I am contacting you regarding your phone call to me last Friday reference Application **LU/297/19/PL - Land to rear of 141 Wick Street.**

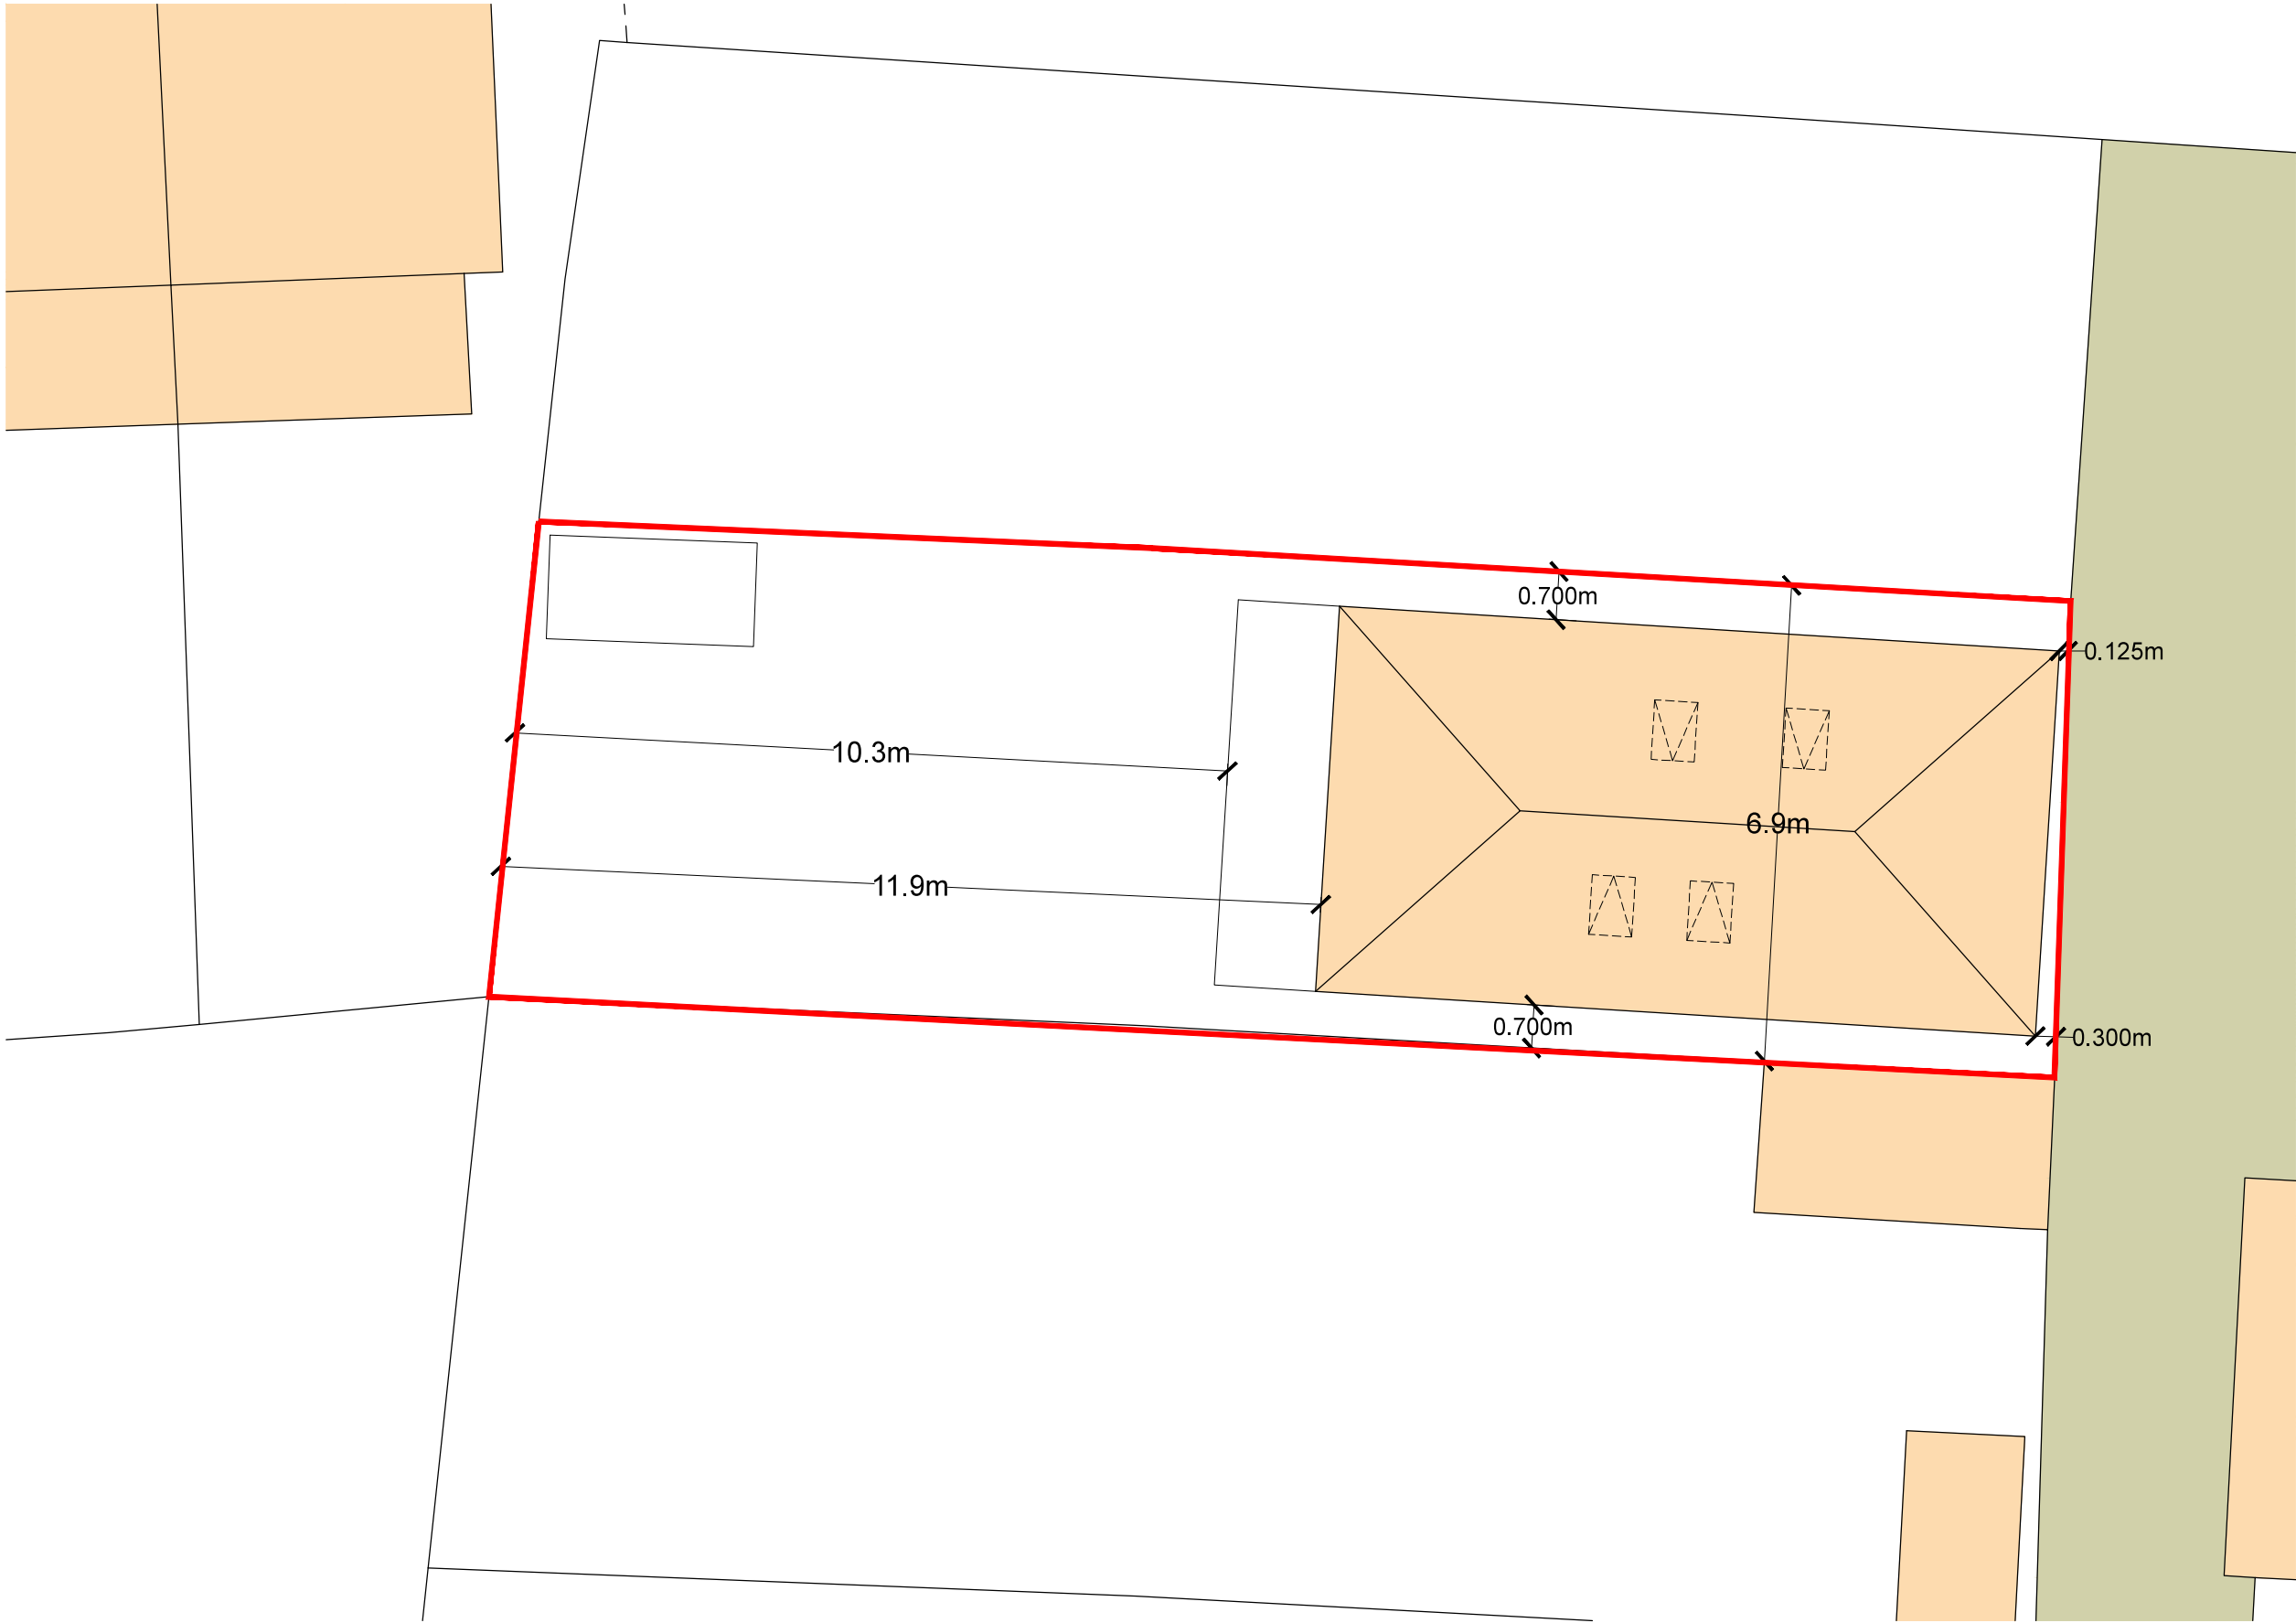
Regarding the changes we have made, this was based on your advice when we last spoke, specifically with the windows on the east elevation towards 141 Wick Street, I asked you want the recommend distance that was required between the two buildings and you said this was 20m which we have achieved by moving the building further back and we now have 21.6m between the front and 141 Wick Street which addresses the issue you raised.

To accommodate the concerns of overlooking at the front of the property (towards the East) we have moved the proposed building back from the front of the site by 4.8m this now gives a total distance of 21.6m from the front of the new dwelling to the back of 141 Wick Street, this now solves the issue of overlooking into 141 Wick Street, and it also has the added benefit of allowing more than 1 car to park in front of the property.

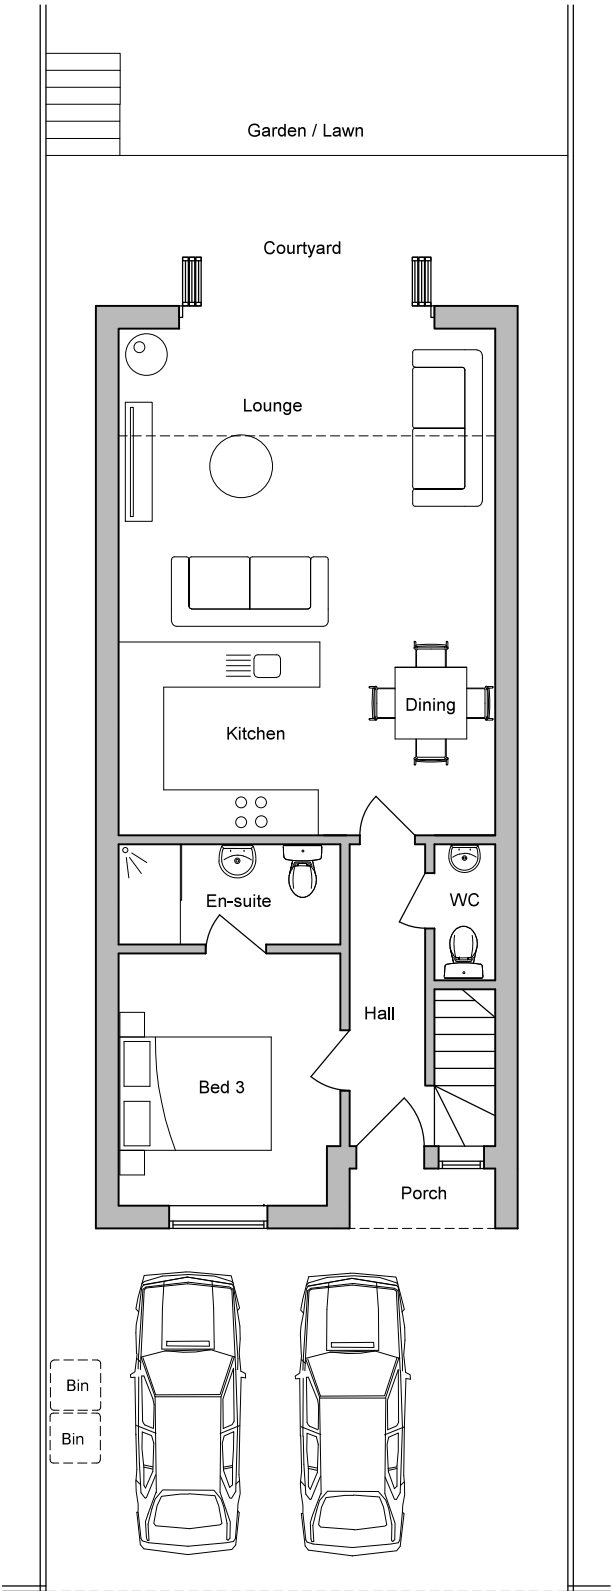
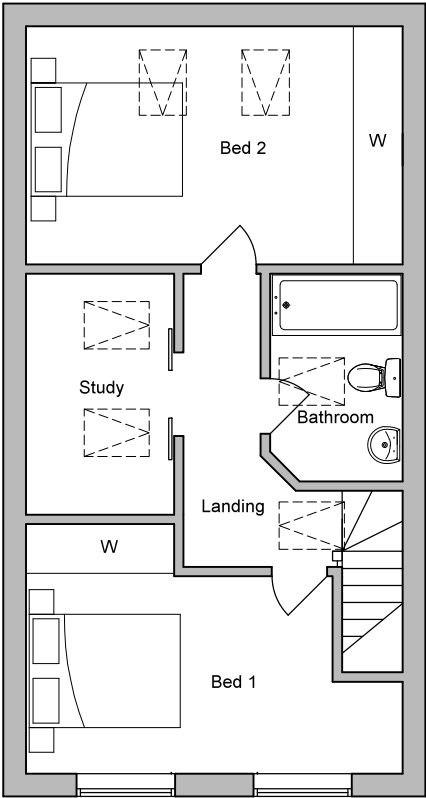
Thank you for the information which I was made aware from my site visit this morning and speaking to 141 Wick Road. Zac will prepare a report to acknowledge the fact that this is not garden land. However, with regards to the western section the two first floor windows will need to be replaced by velux windows. With this change made I also need to make you aware that whilst a report recommending permission it needs to be signed off as agreed by the Group Head before it goes on the agenda for the Feb development control committee.

I have now had an opportunity to assess the changes. I am afraid that the relationship between the neighbouring properties to the east and west is still unsatisfactory with regards to overlooking of rear gardens from proposed 1st floor windows. The only way that this could be overcome is by the use of Velux windows so that becomes a proposal for a chalet bungalow and not a two storey dwelling. As such the intention is to refuse this application if I don't hear in the next two days.

Please find attached all the revised drawings for Mr Denton to write his report. The drawings now show the velux in the western elevation.

458 - DPA 04

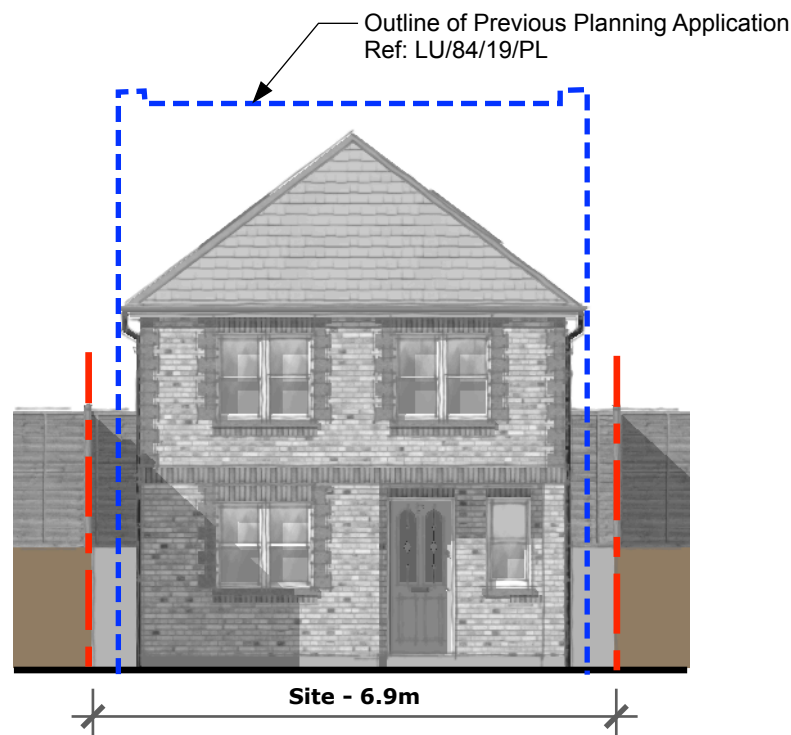
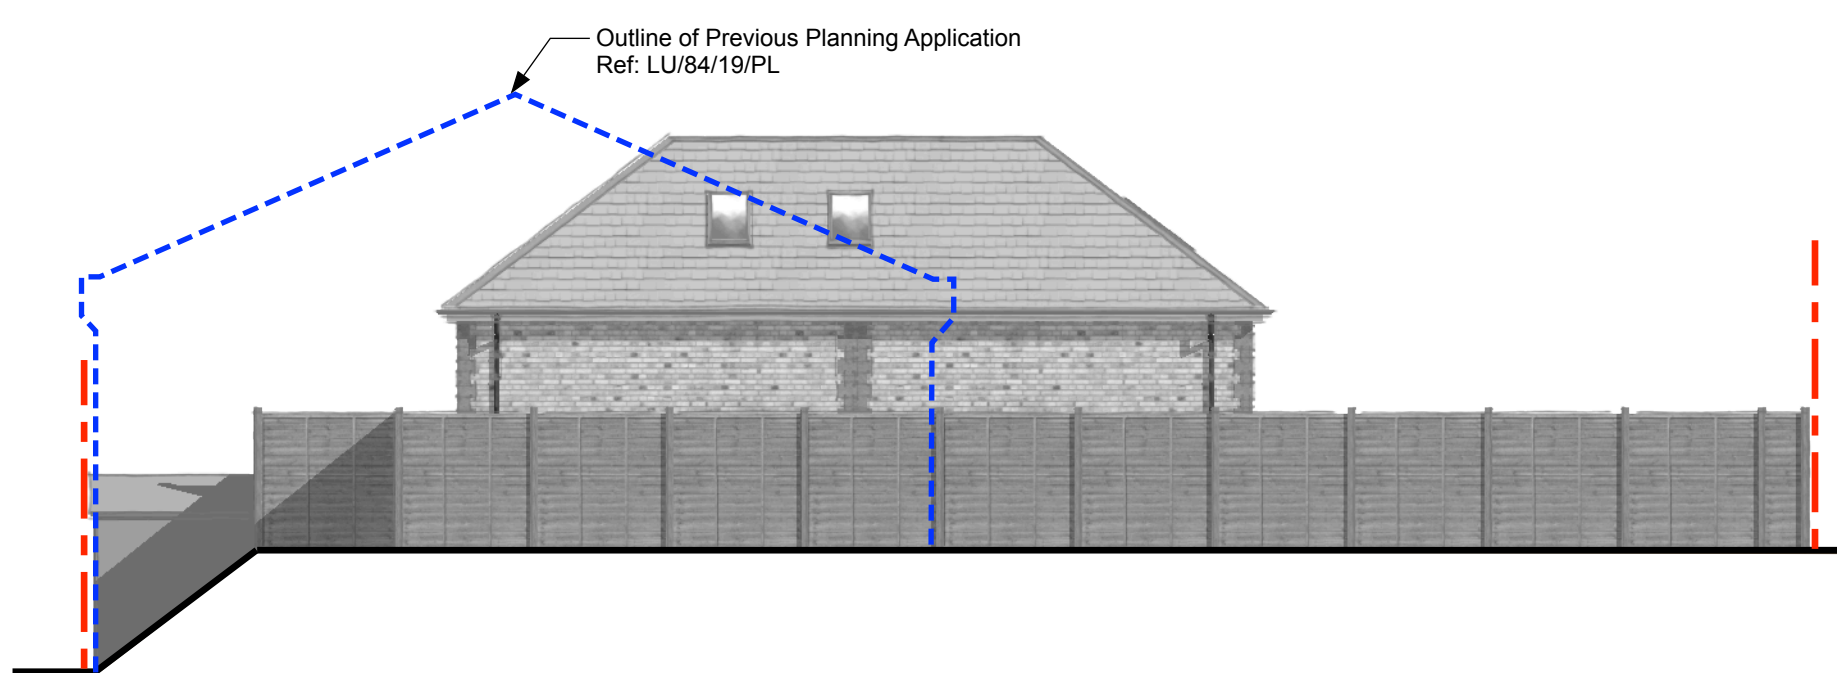
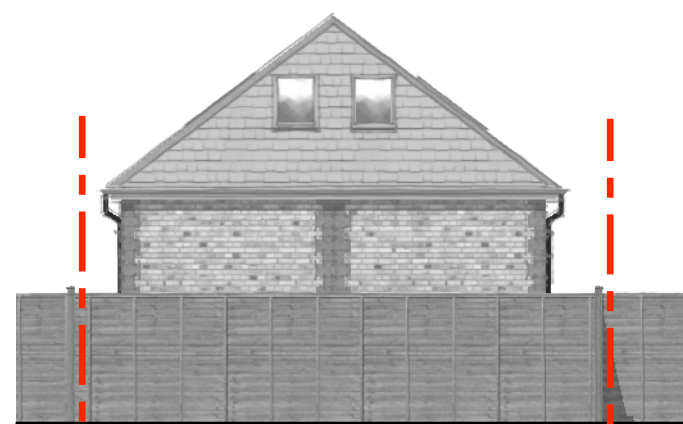
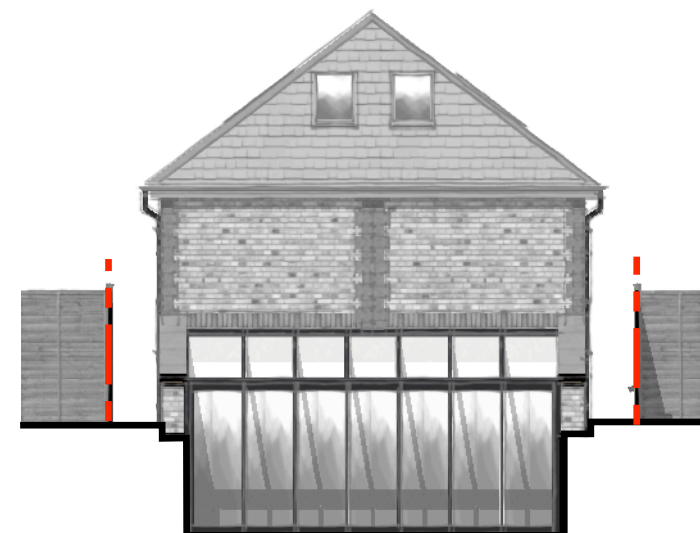
I am disappointed to hear that you still feel that there is an issue of over looking to the east and west.

The Applicant would be accept replacing the windows at the rear of house to the West with velux windows to overcome the overlooking issue and I can forward you revised drawings showing this.

If the issue is also at the back I would propose that we replace the windows facing West with velux in the roof and keep the windows at the front.

458 - DPA 05

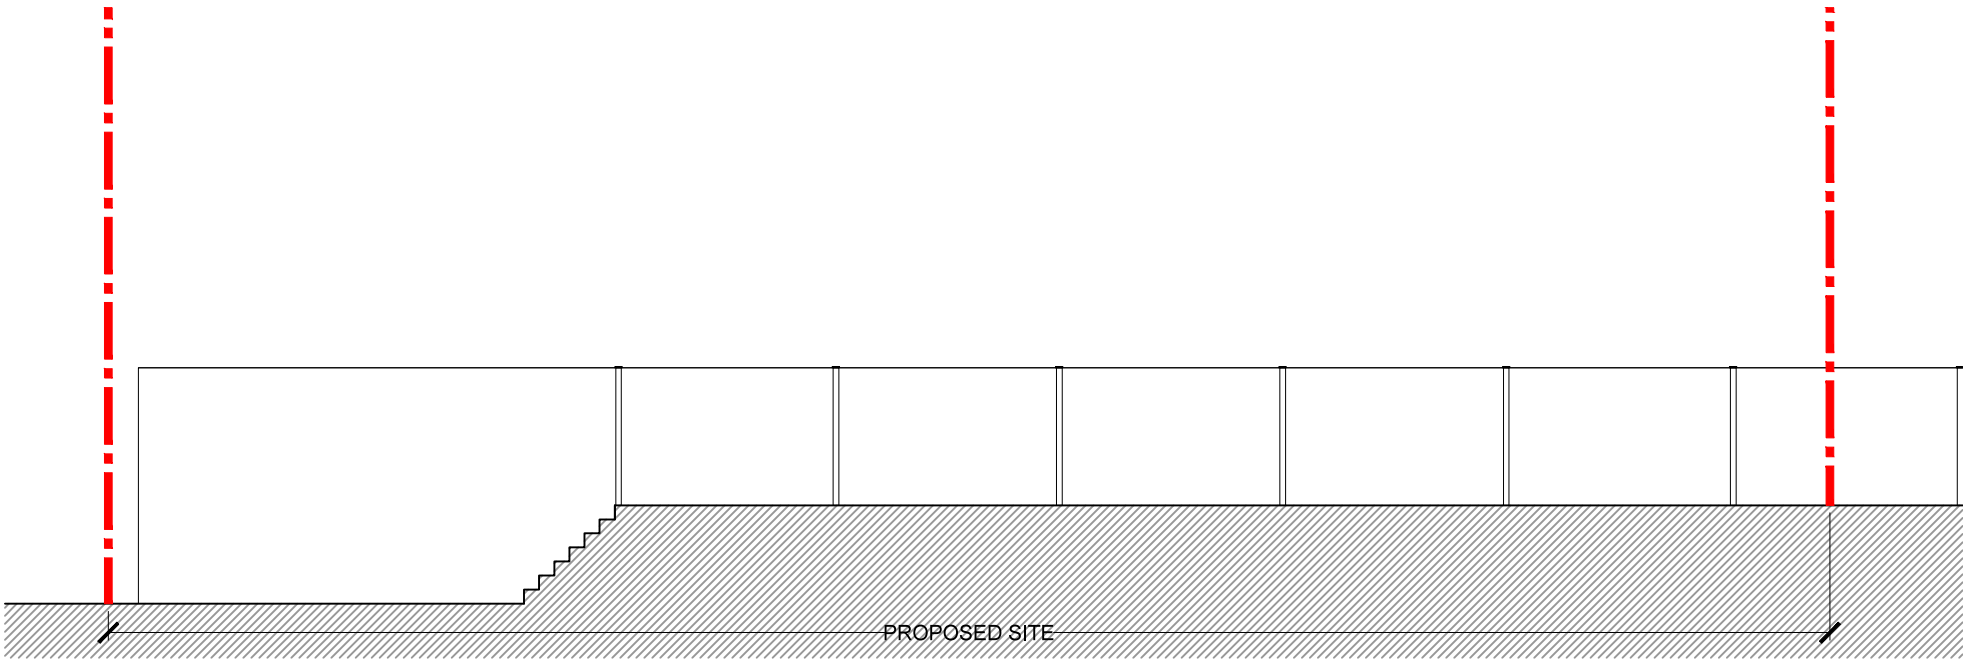
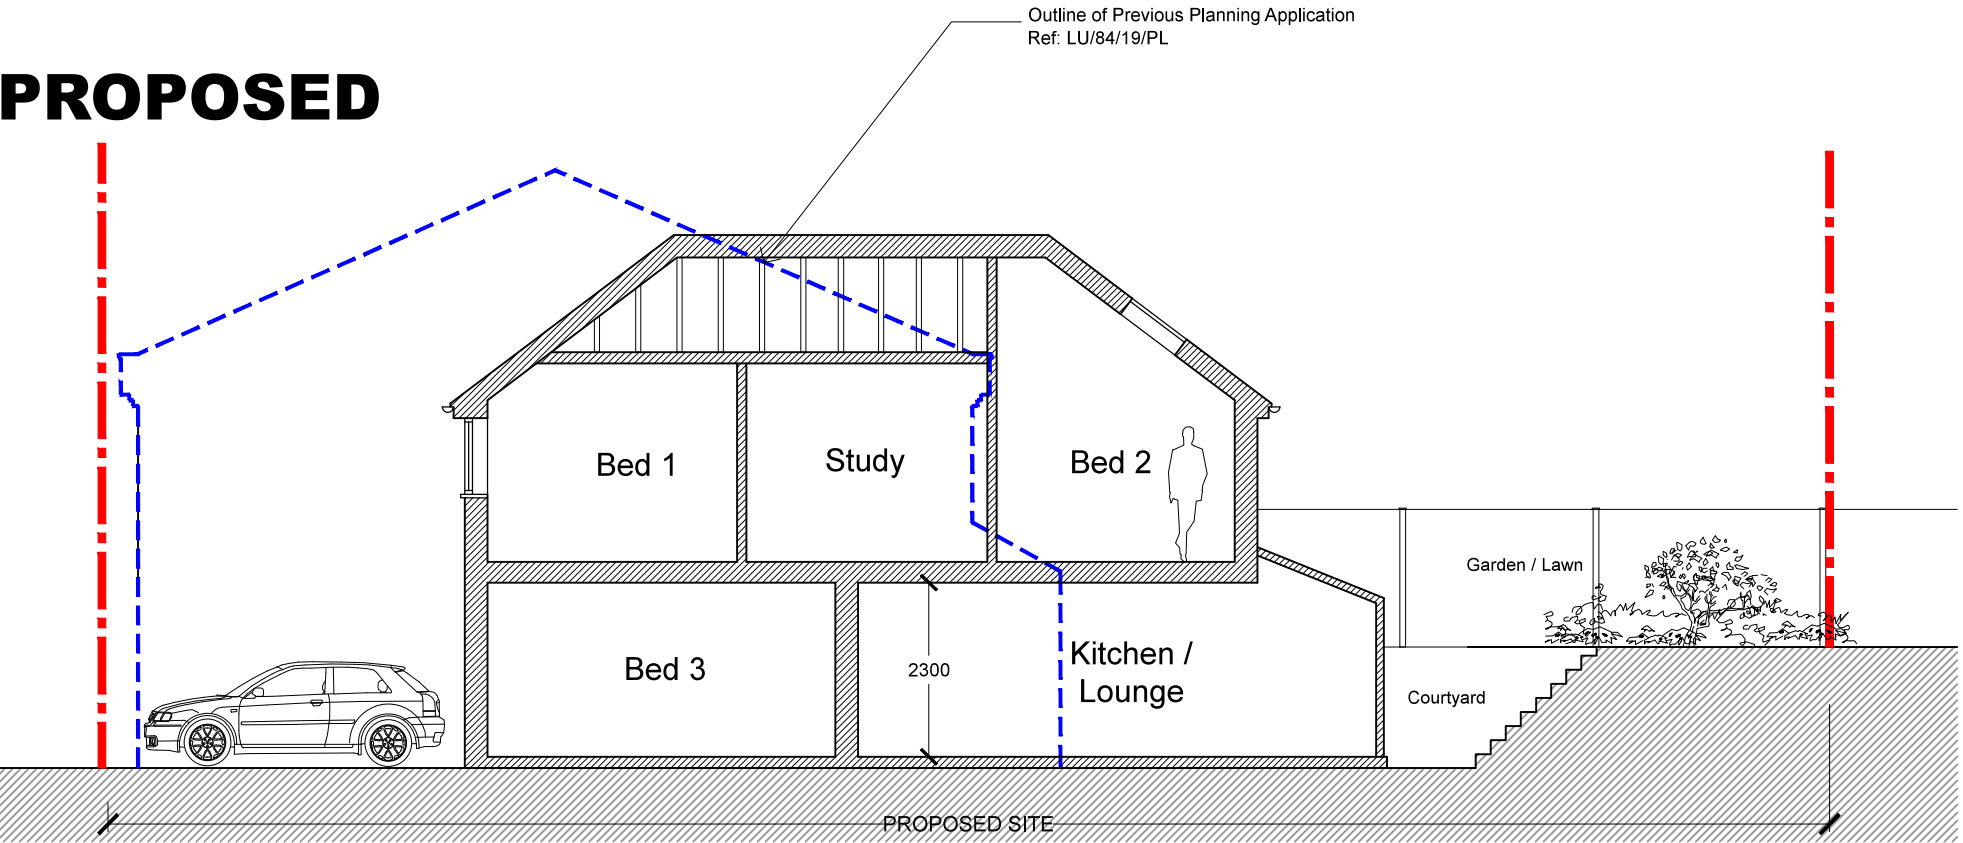
With the location of the building changing as mentioned above I have looked carefully at the resulting visual amenity to the rear of the property (towards the West). To work out the result of any overlooking I have drawn a site section to see how this may or may not be effected. If you look at the attached drawing **458-DPA-09 - Section B-B** you will see that because the house is lower than the ground level of Colebrook Road the actual line of sight from the rear windows does not allow you to see into the gardens of No.66 or No.64 Colebrook Road, this is because the house is lower in the site which means the angle of vision passes above the fence lines and does not allow you to look into the gardens.
